Application No: BR/55/20/PL
Site Address: Abbots Lawn Sylvan Way Bognor Regis PO21 2RS
Description of works: Proposed first and second floor extensions.

Thank you for your internet representation made on 30th May 2020 which has been recorded as an objection with the comments as follows:

Proposed North Elevation

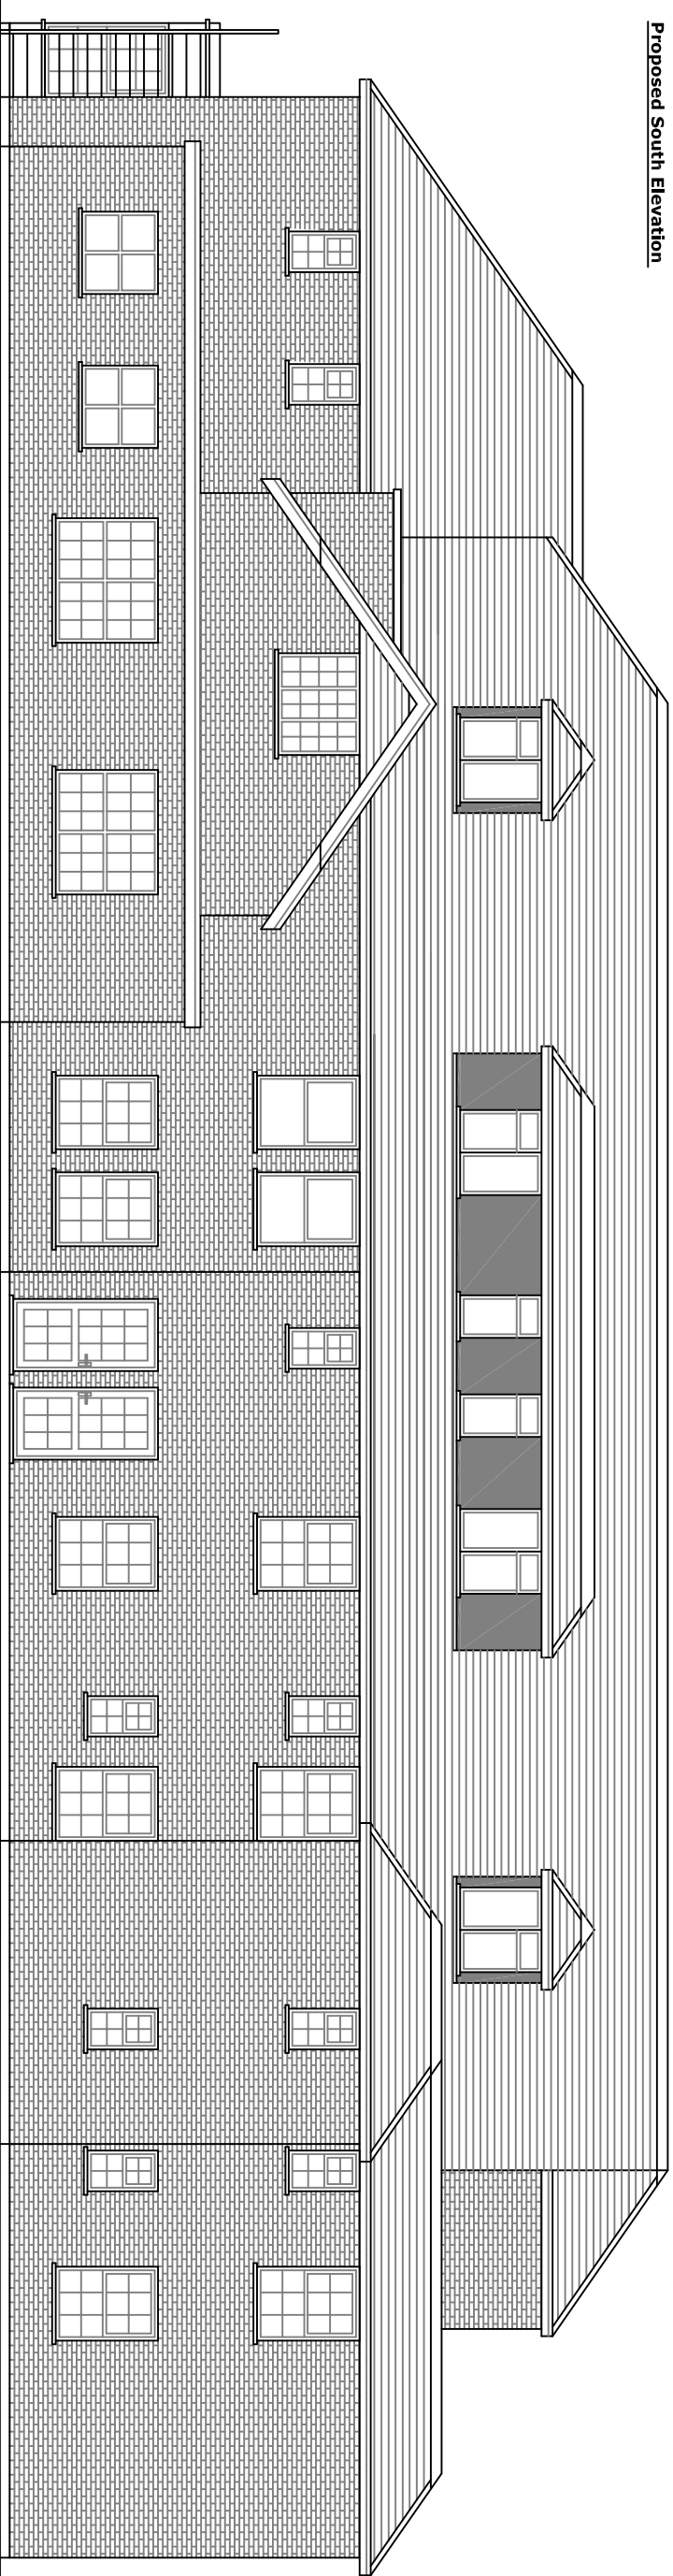
Additional windows will face northwards, overlooking Elfin Grove, on a property that is already very close to the boundary fence. Additional height will make for a very imposing and substantial construction.
